6615 and 6635 Renaud Road, 191 Rappel Circle

Planning Rationale + Urban Design Brief
Zoning By-law Amendment
March 17, 2025

Prepared for Richcraft

SITE PLAN

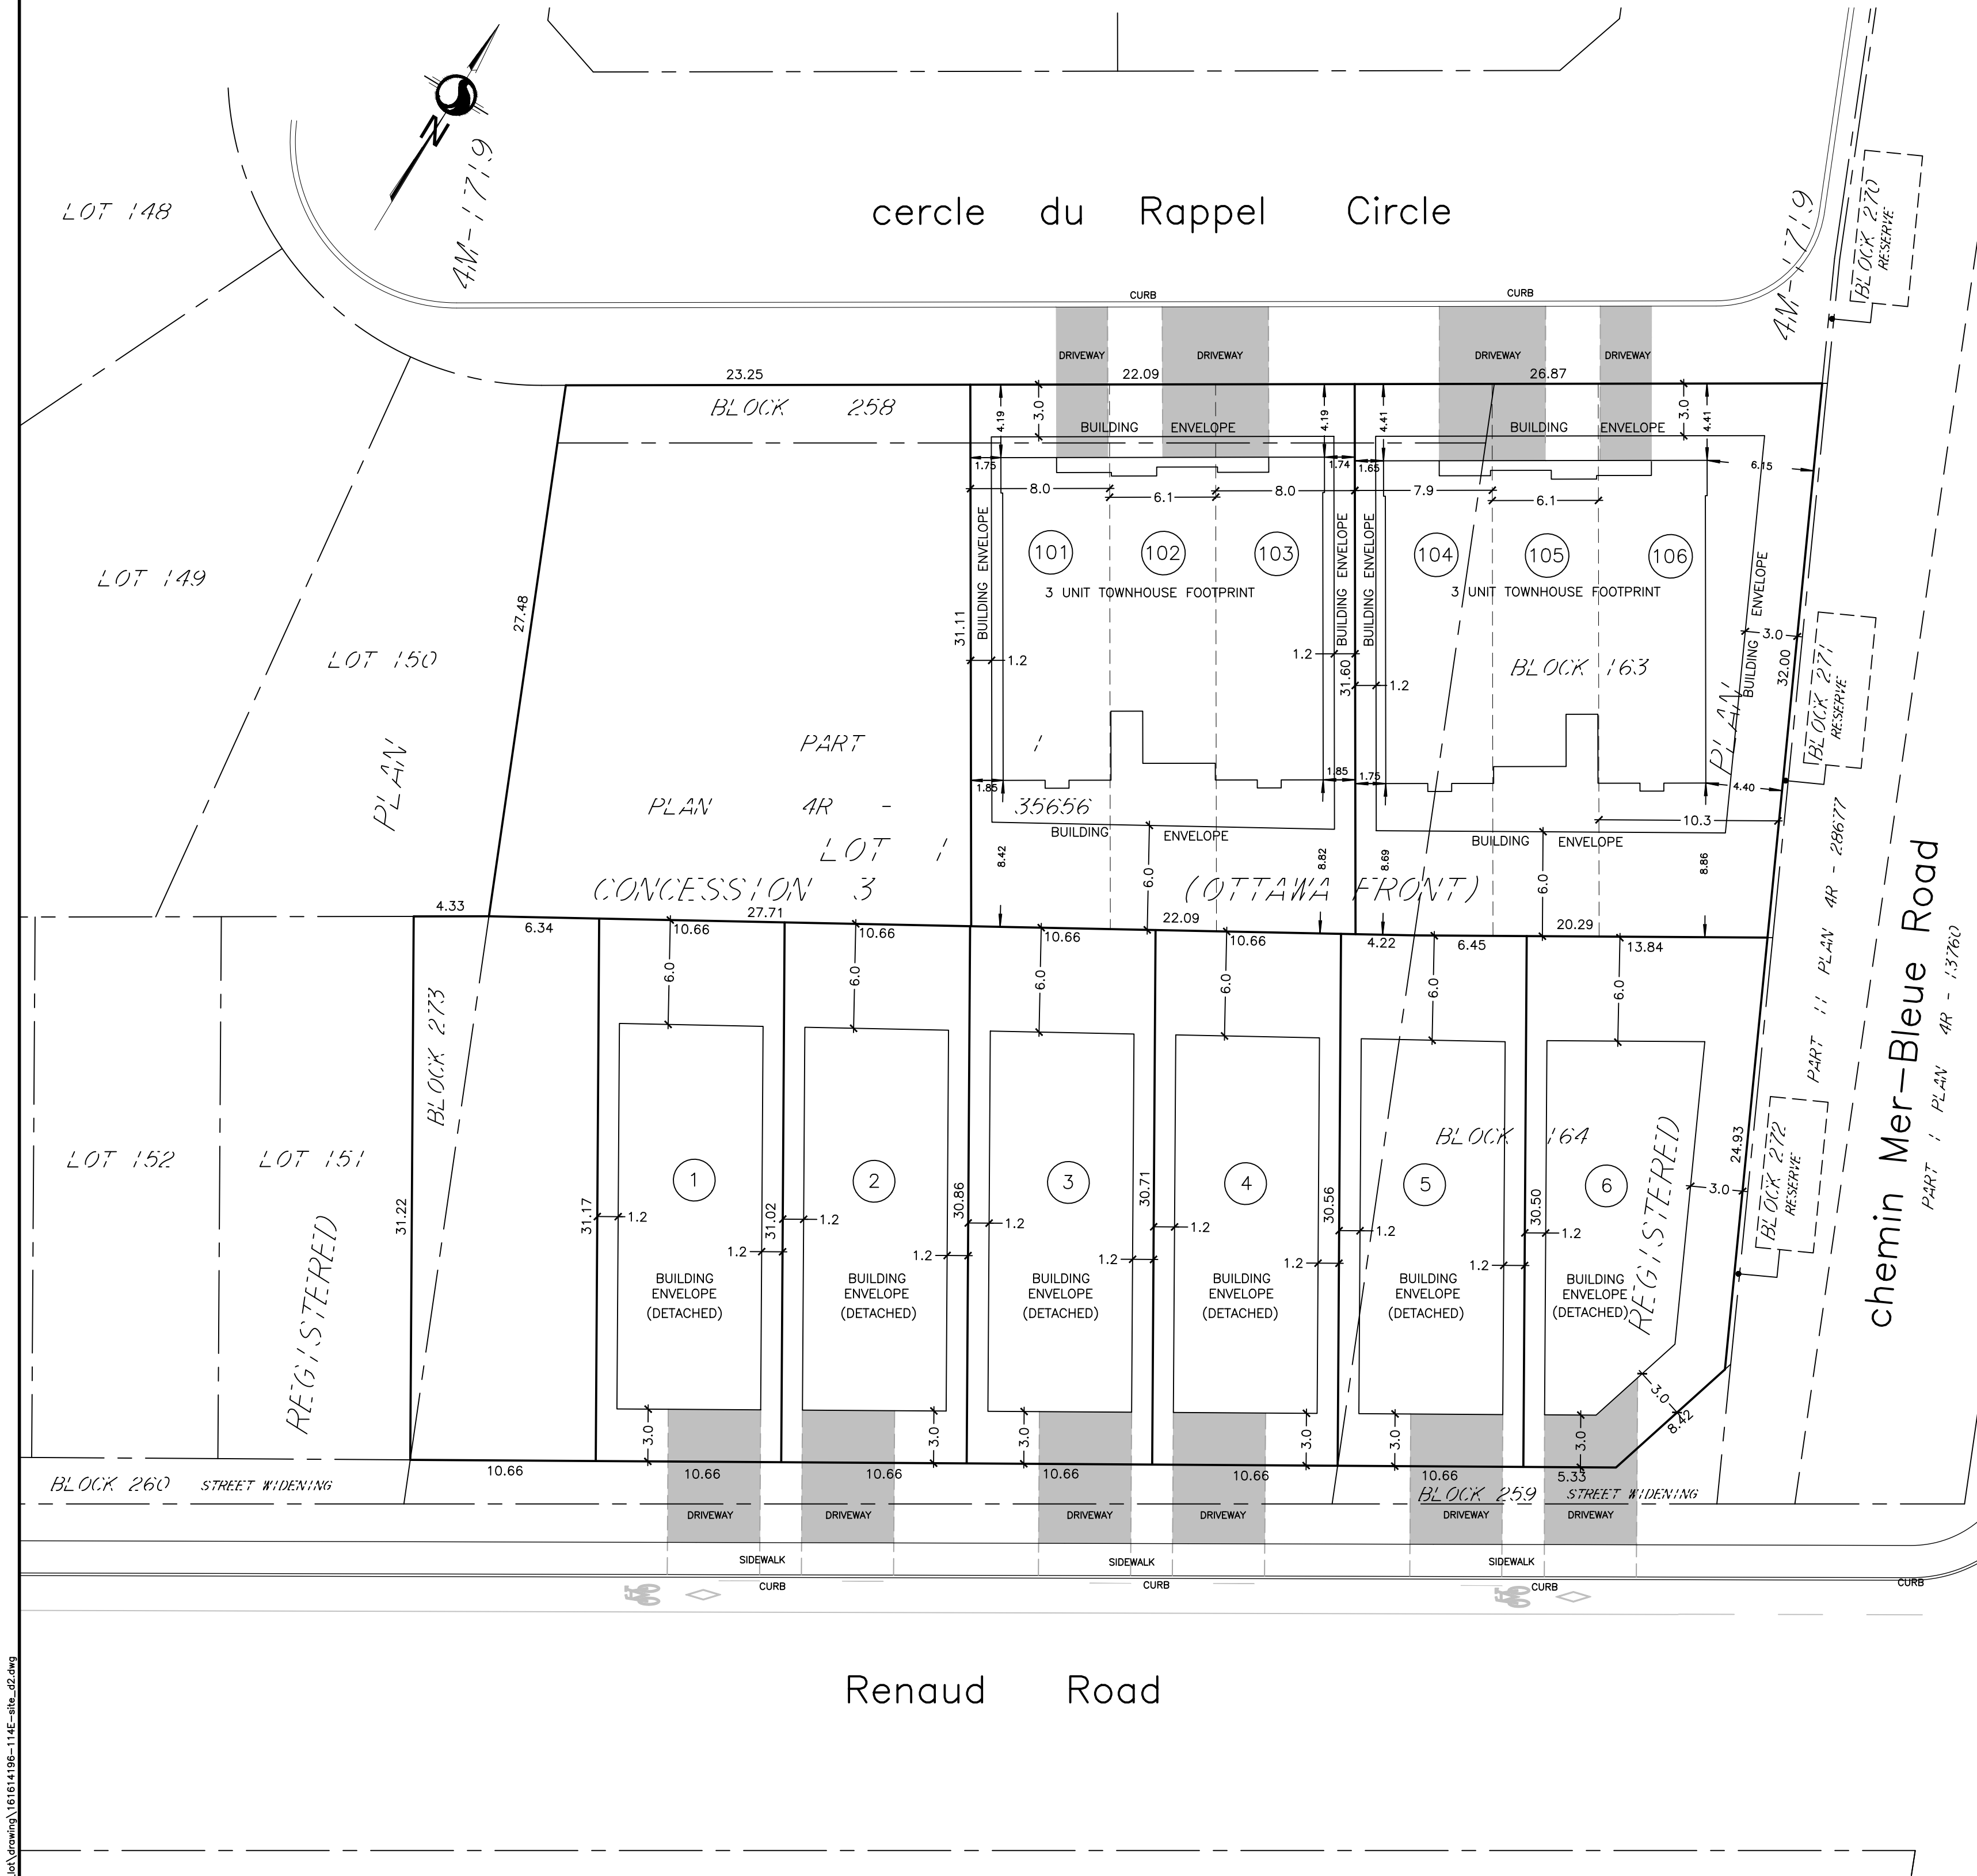
- 1. Front yard setbacks should align with adjacent lots along Renaud Road and Rappel Circle. Any road widening should be considered when determining front yard setback.**

The front yard setbacks of the proposed dwellings align with those of neighbouring lots.

The dimensions of proposed lots fronting on Renaud Road consider the road widening affecting adjacent lots. The suitability of the existing width of Mer Bleue Road was confirmed by City staff and Rappel Circle is not subject to widening.

- 3. It appears that there is a maintenance roadway for the existing cell tower. Please consider providing a public walkway connection between Rappel Circle and Renaud Road along this alignment.**

Providing a public walkway in this location will create a liability and logistical challenge, as the land beneath the cell tower is under a fifty-year lease and requires a private access lane. The lessee will not permit public access to the land, and it is to be developed for residential uses when the lease expires.

PRELIMINARY
LANDSCAPE PLAN

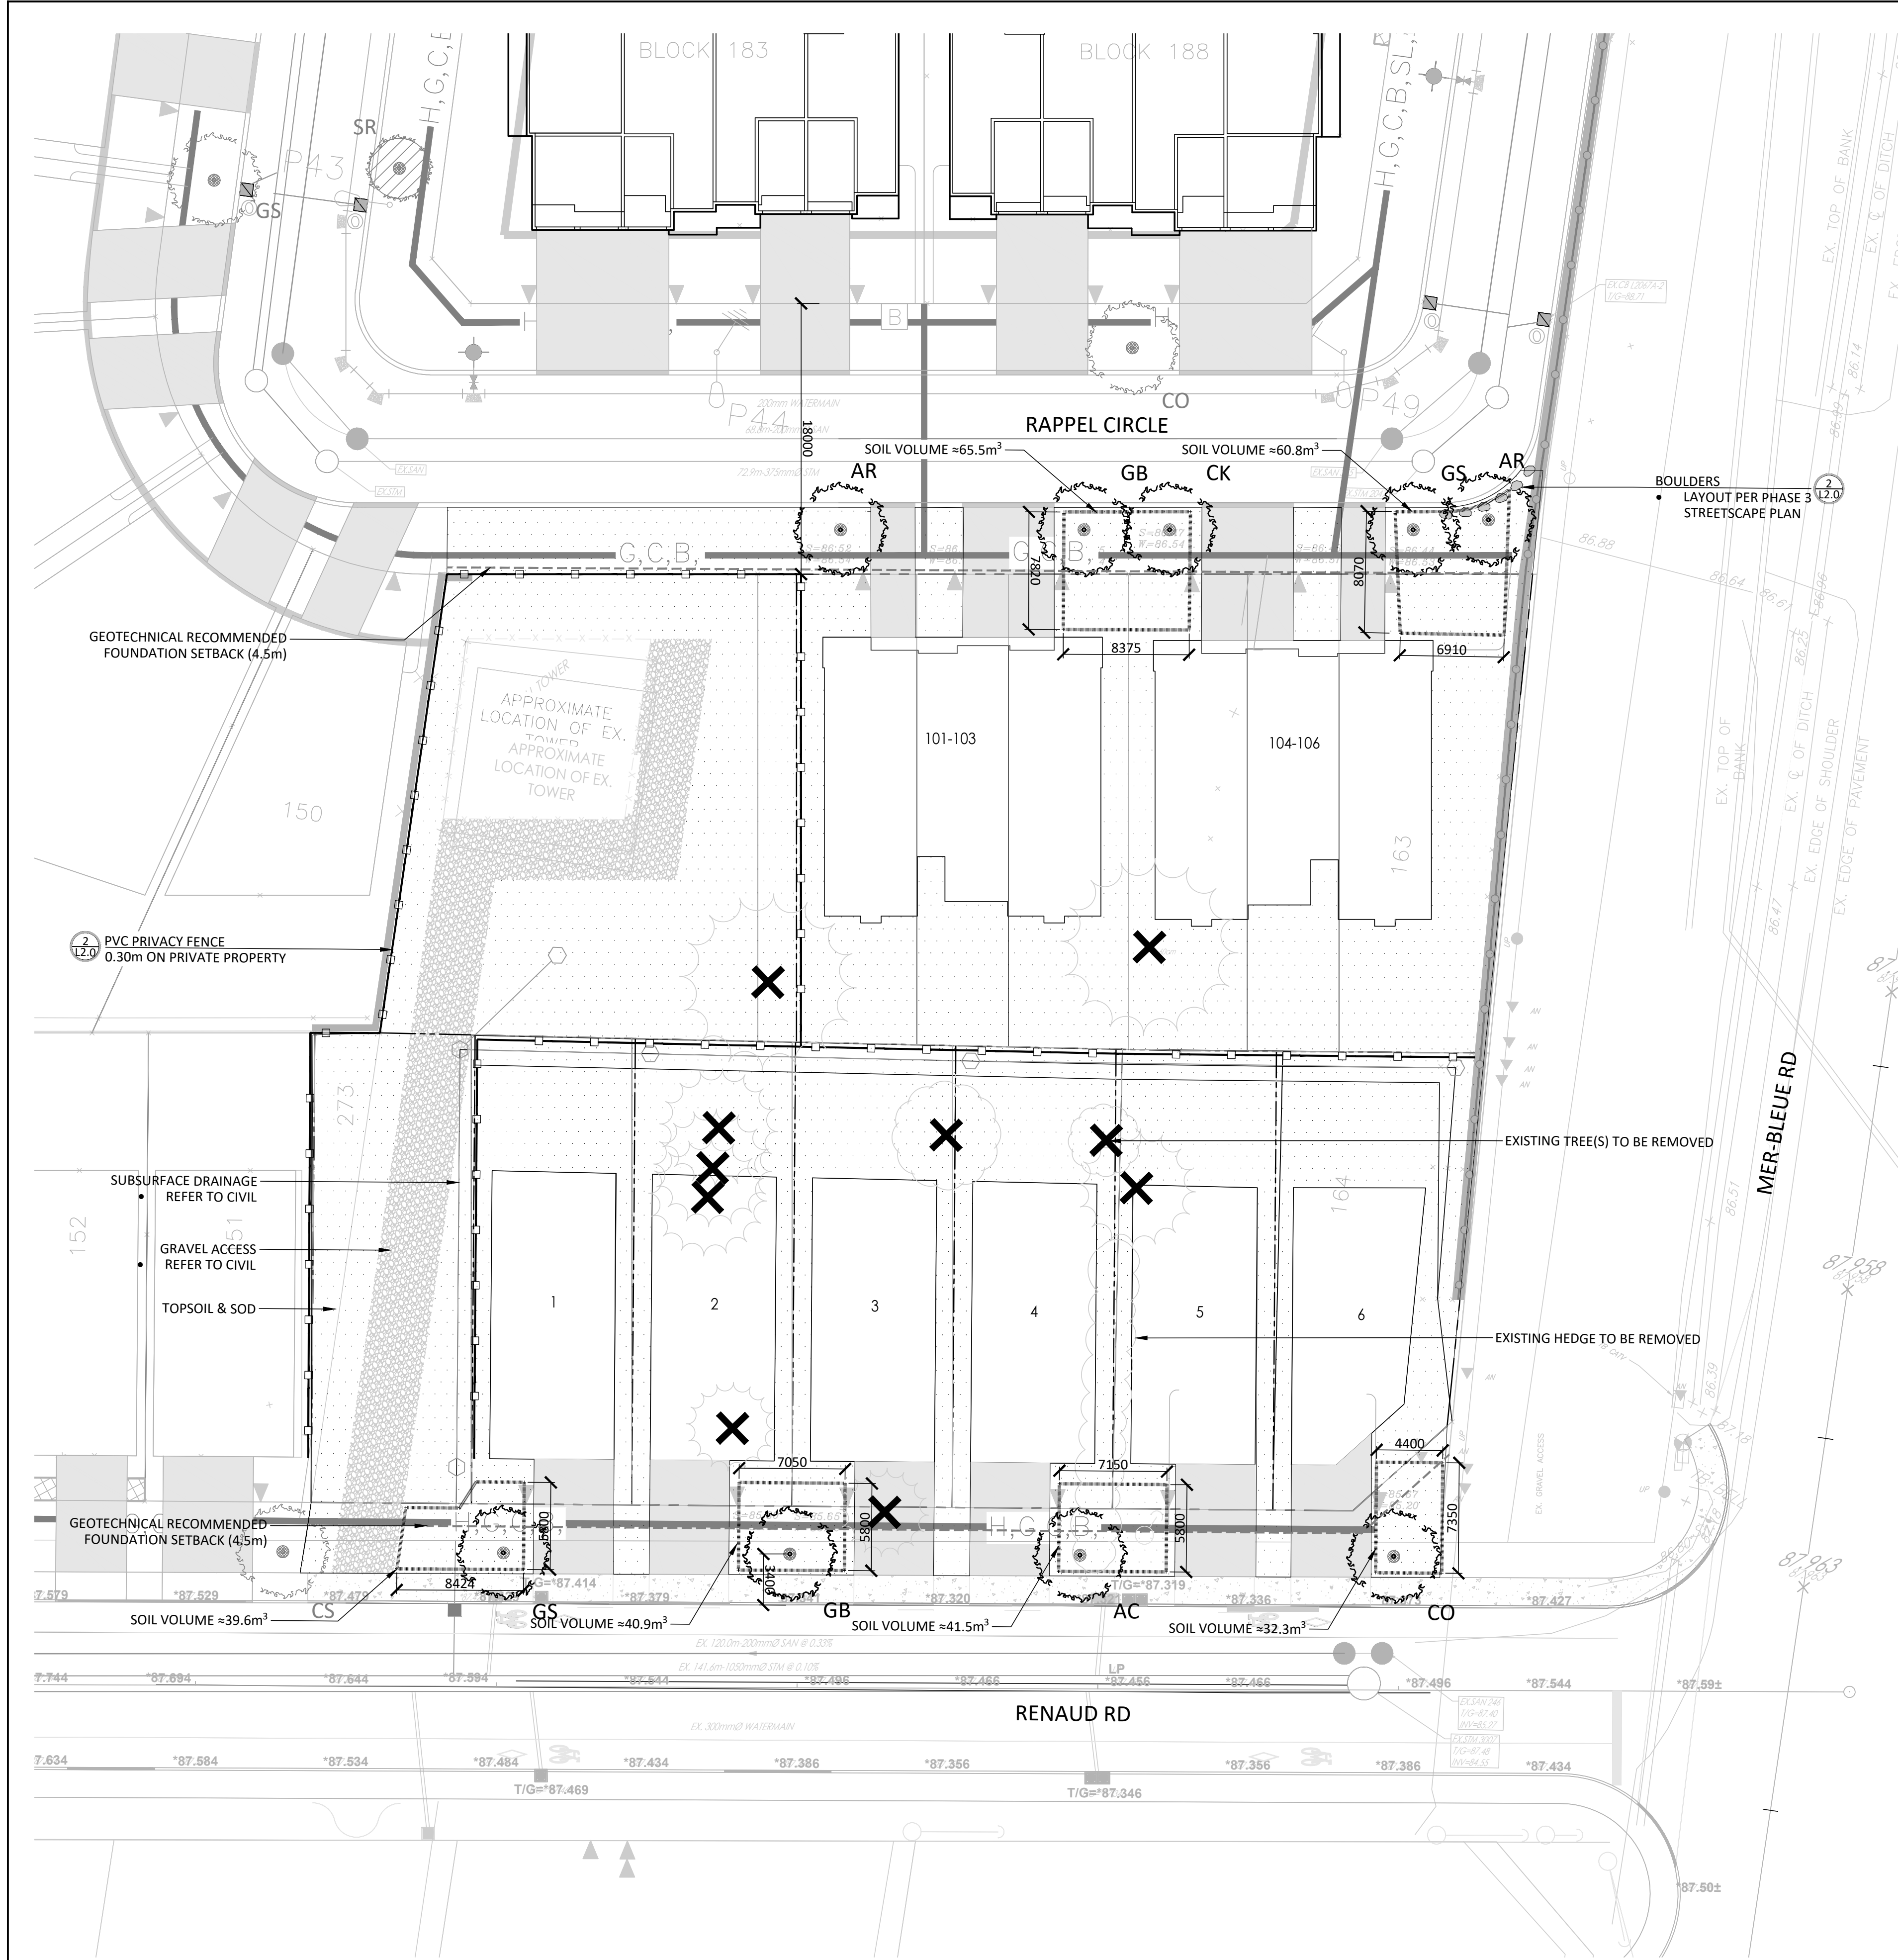
- 2. Please ensure that street trees can be planted. Driveways may need to be paired or lot widths may need to increase to provide trees. Please illustrate on the concept plan.**

Driveways providing access to townhouse dwellings fronting on Rappel Circle are paired and arranged to reduce public realm impacts. This has resulted in two soil volumes of 65.5 and 60.8 cubic metres respectively, generously sized to accommodate two medium trees each, per the attached landscape plan. Dwellings proposed to front on Renaud Road are mirrored from each other to pair driveways and leave larger agglomerations of landscaped area for tree plantings, reduce sidewalk impacts, and provide adequate curb space for on-street parking. As such, four medium street trees are proposed in areas with soil volumes ranging from 32.3 to 41.5 cubic metres.
